15th June 2015

R/114/15/HH – Two storey rear extension and single storey rear annexe – 81 Sea Avenue

PROPOSED ELEVATIONS 1:100

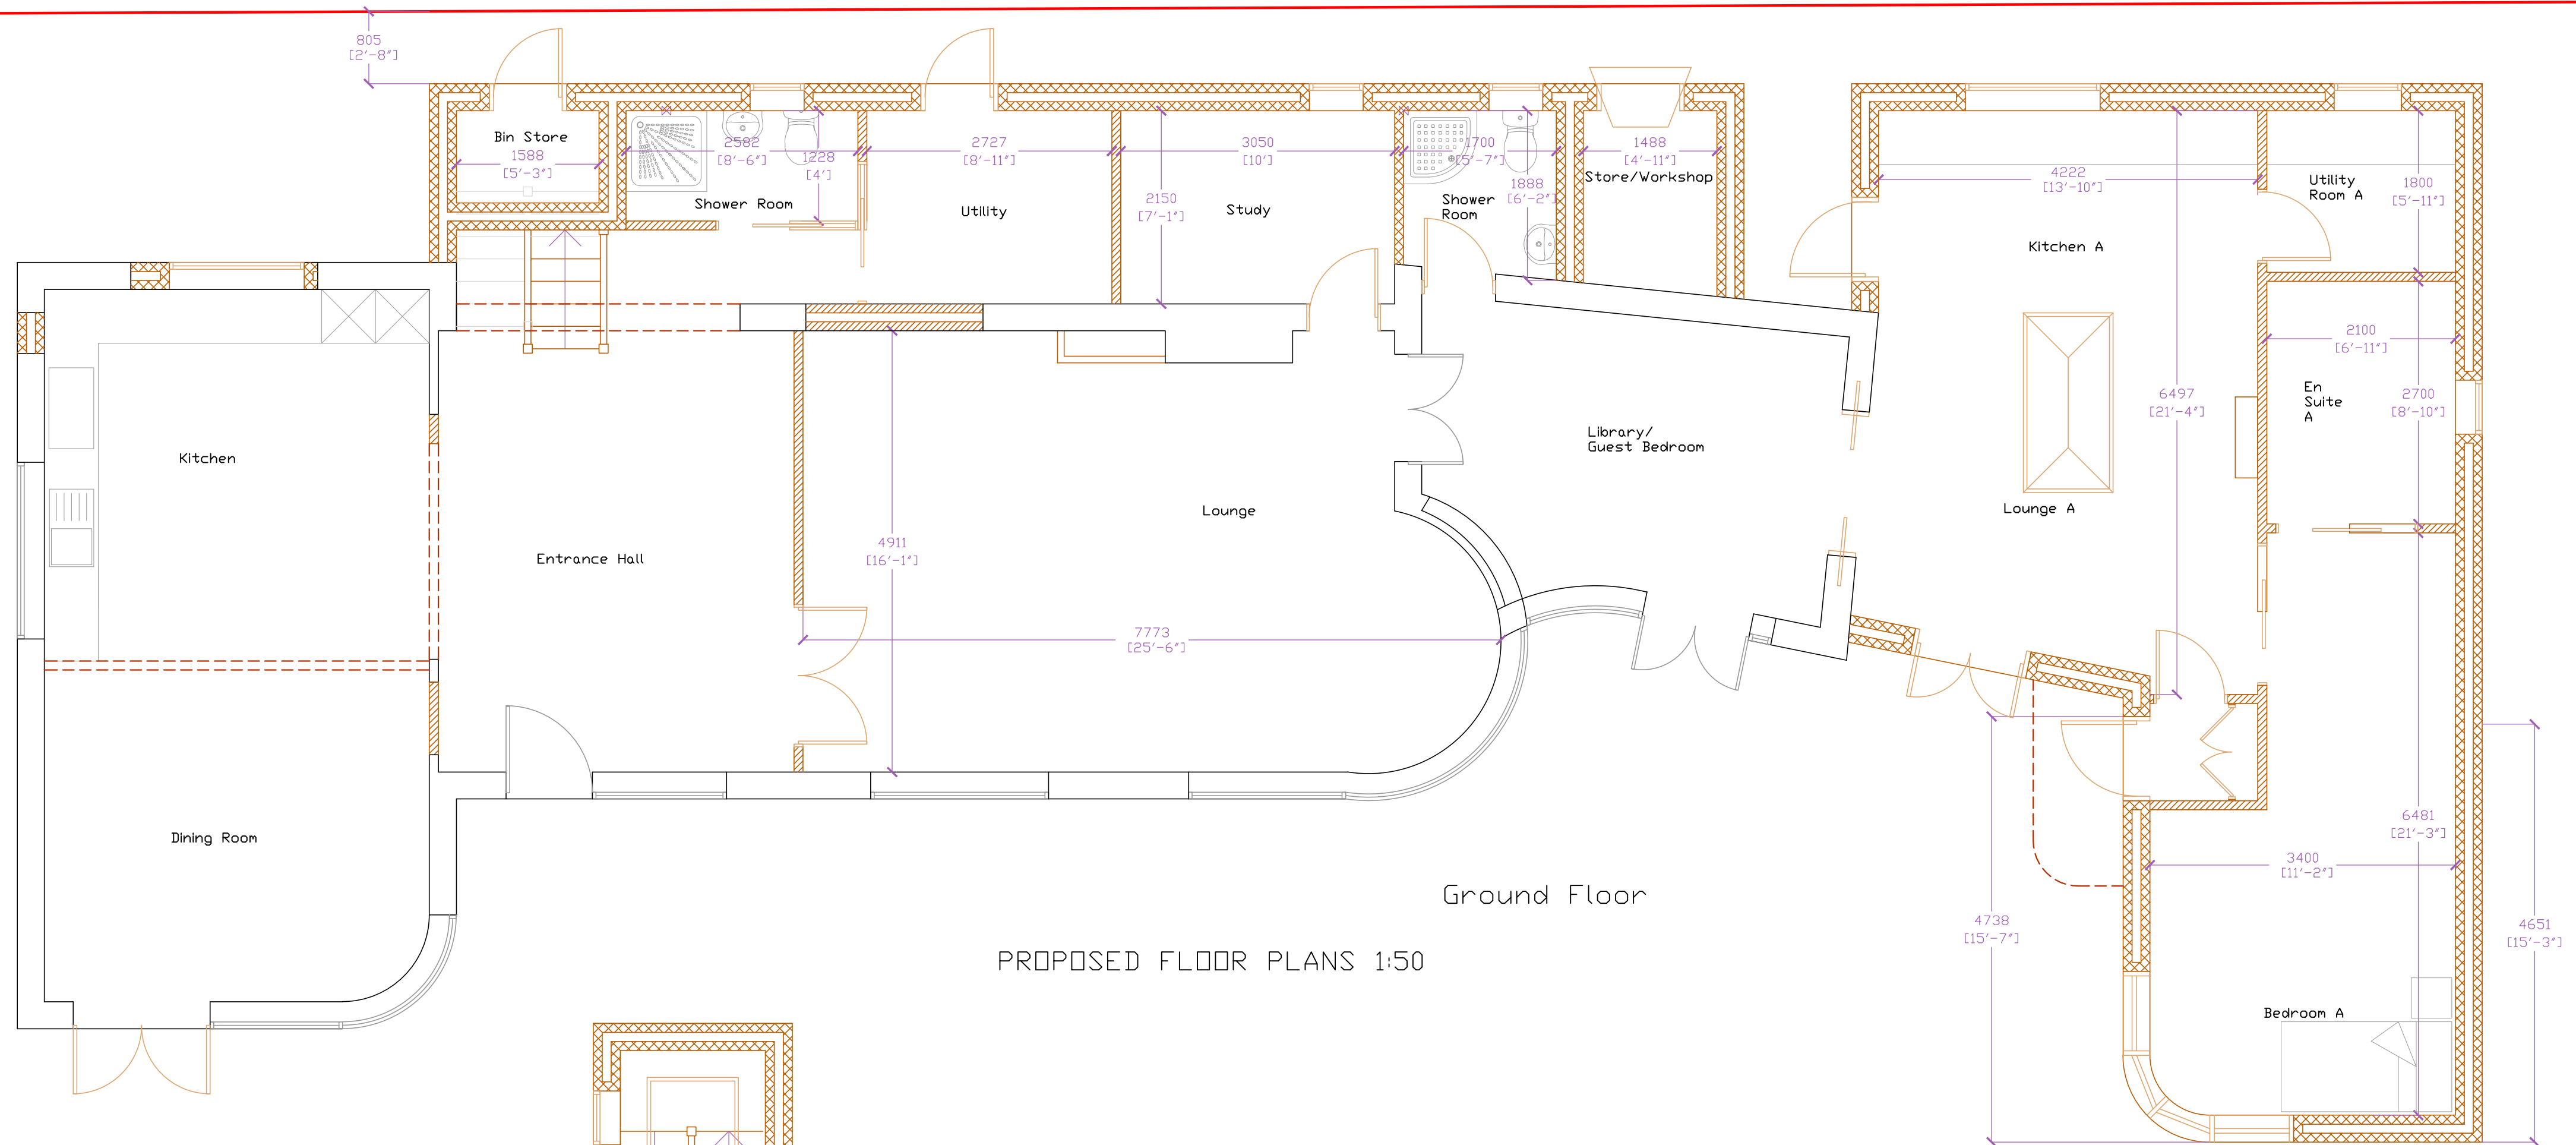
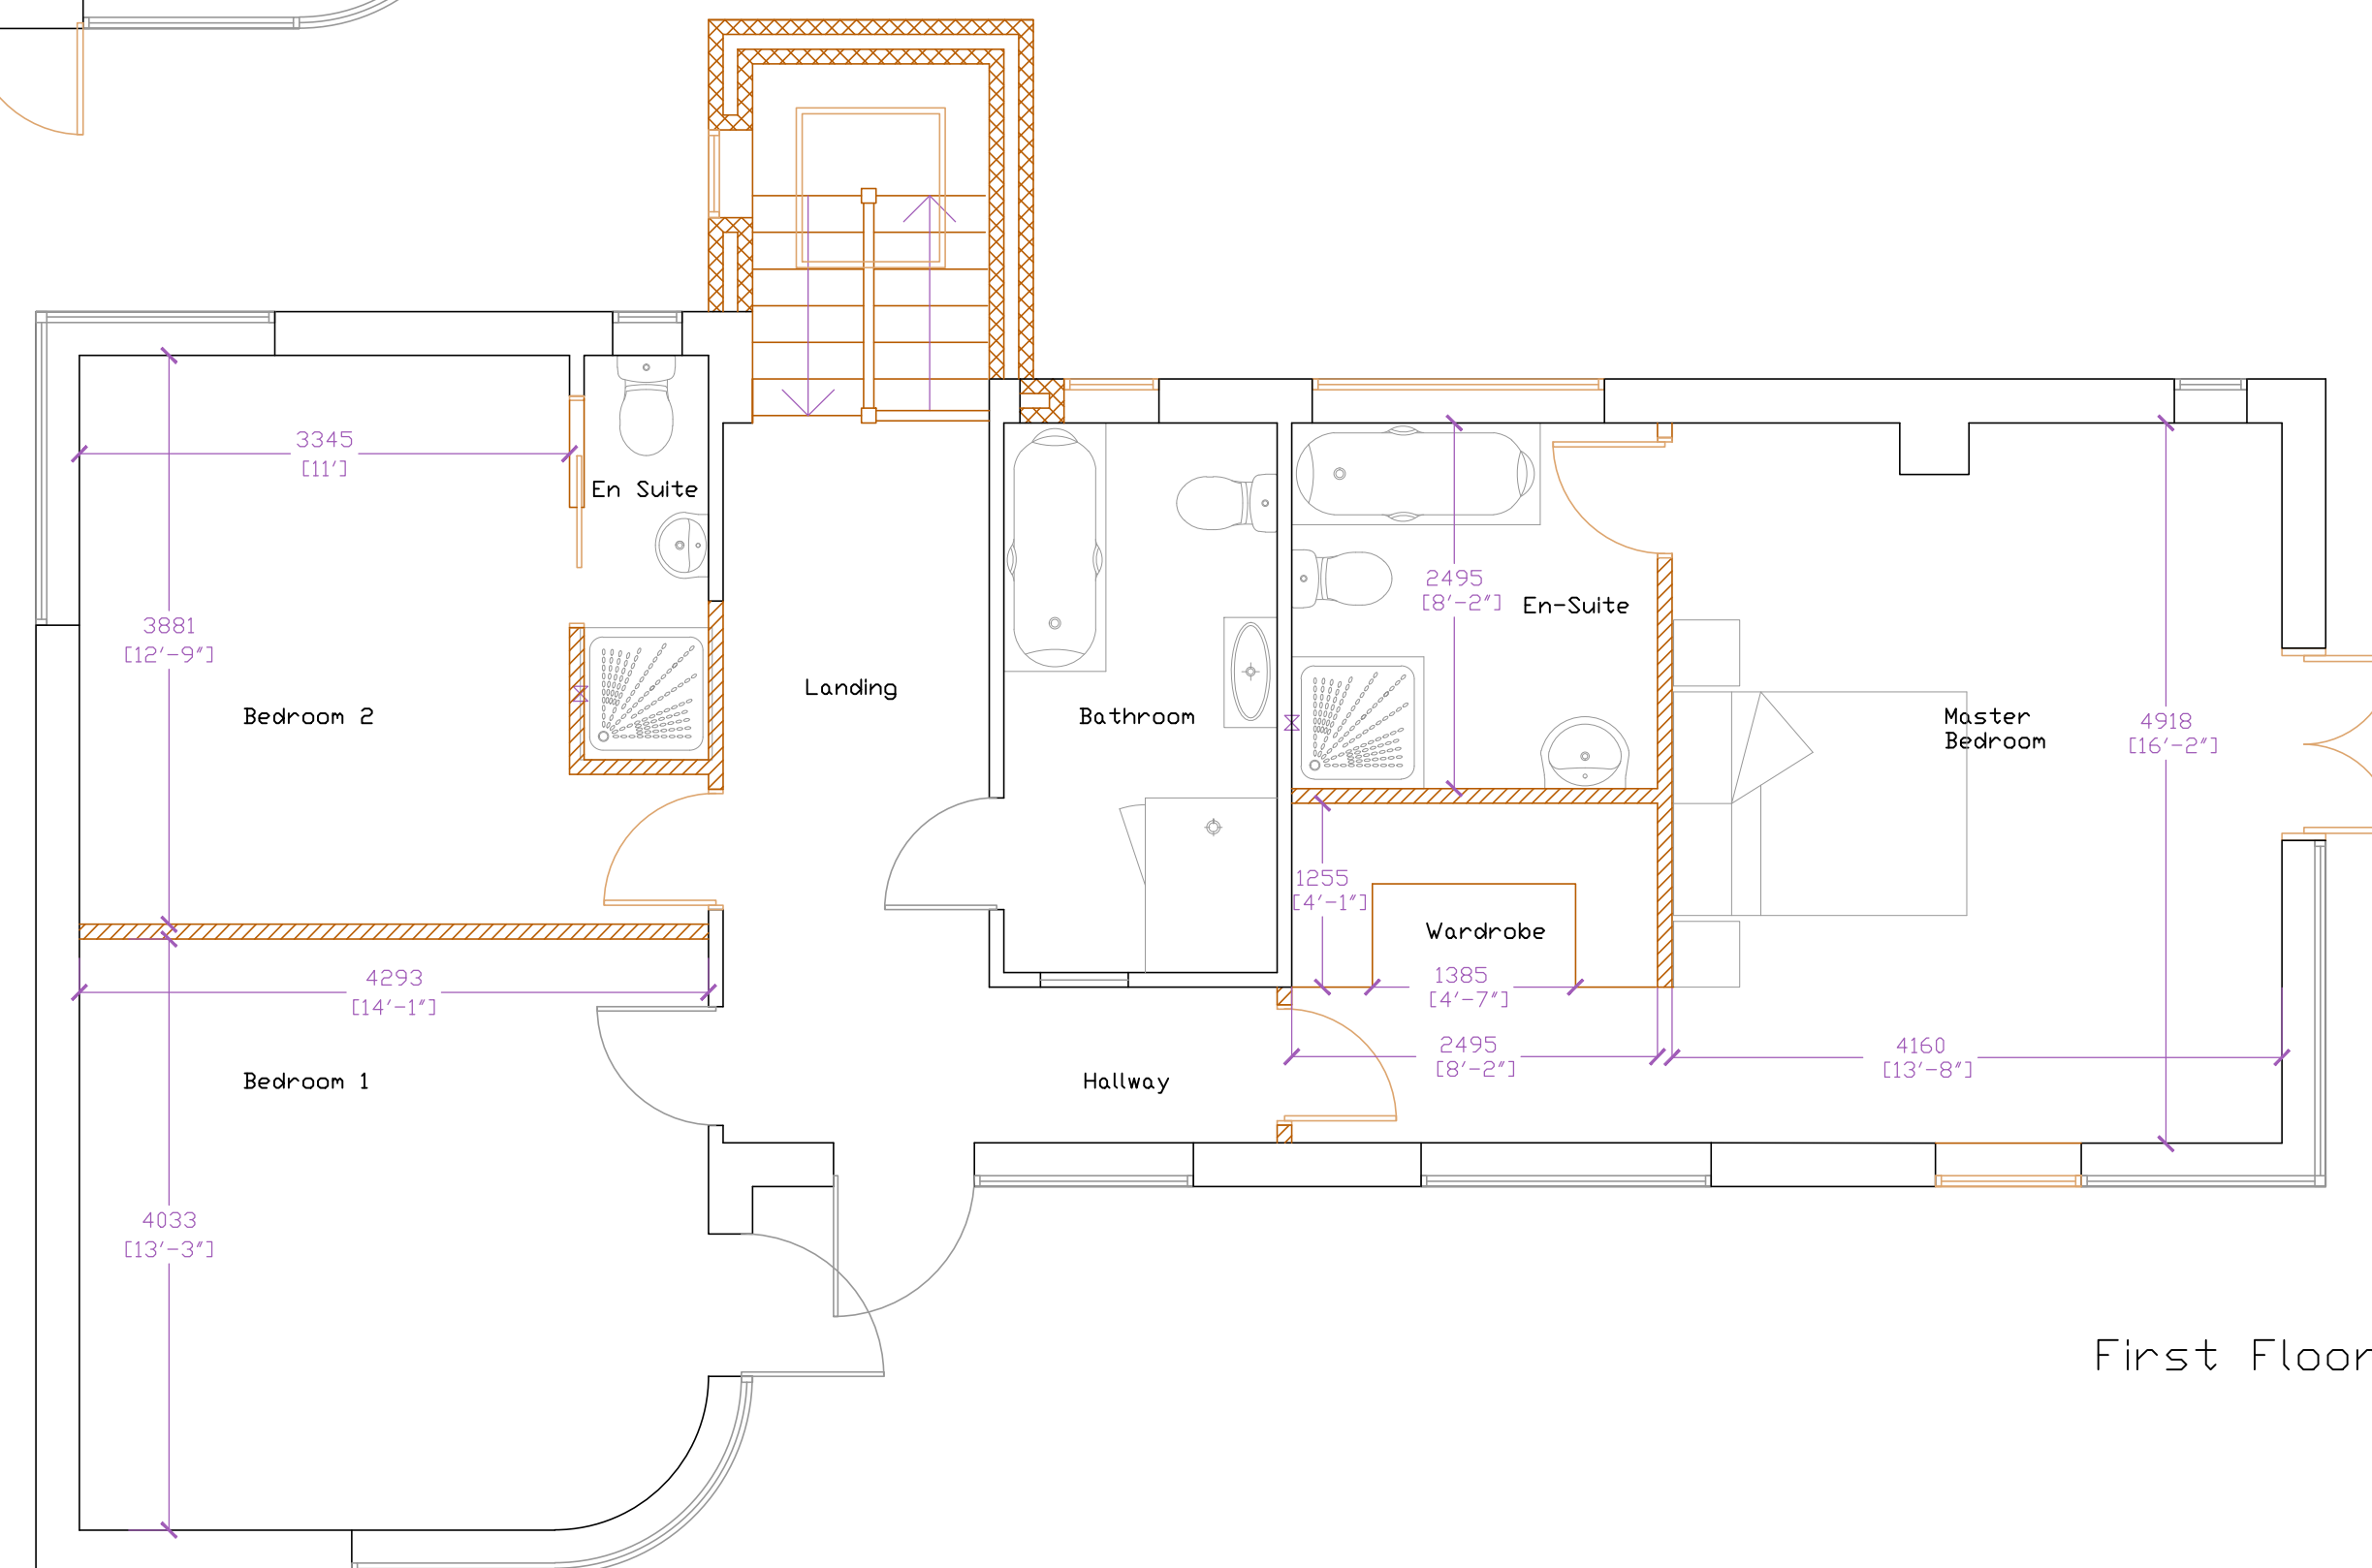
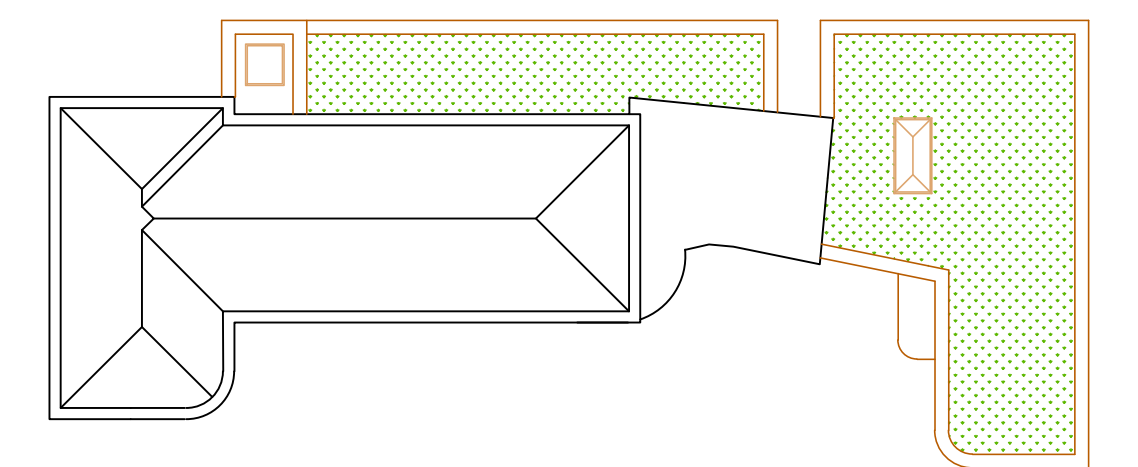
1. The scale and mass of the proposal, in particular the overbearing scale of the rear annexe. The extension and annexe will increase the ground area of the property by over 50%, with the annexe effectively creating a new four roomed bungalow attached to the main house, substantially altering the spatial character and pattern of the property. This does not seem to meet the requirements of the Arun Local Plan (2011-31 Publication Version) section 13.4.3 or 13.4.4 or Policy D DM4 sections a,c or e or those of the Arun Local Plan (2003) Policy Dev 19 sections i, iii or v.

3. The proposal would increase the occupational capacity of the house as well as the ground area, both increasing the probable use of water and reducing the area of garden. This increases the flood risk in an area that has for many years been prone to rainwater flooding (for which Arun District Council engineers have worked with the Sea Estate Residents to undertake expensive measures to reduce the risk and impact of surface flooding). This would seem to contradict the requirements of the Arun Plan Policy W DM2 and Rustington Plan Policy 4.
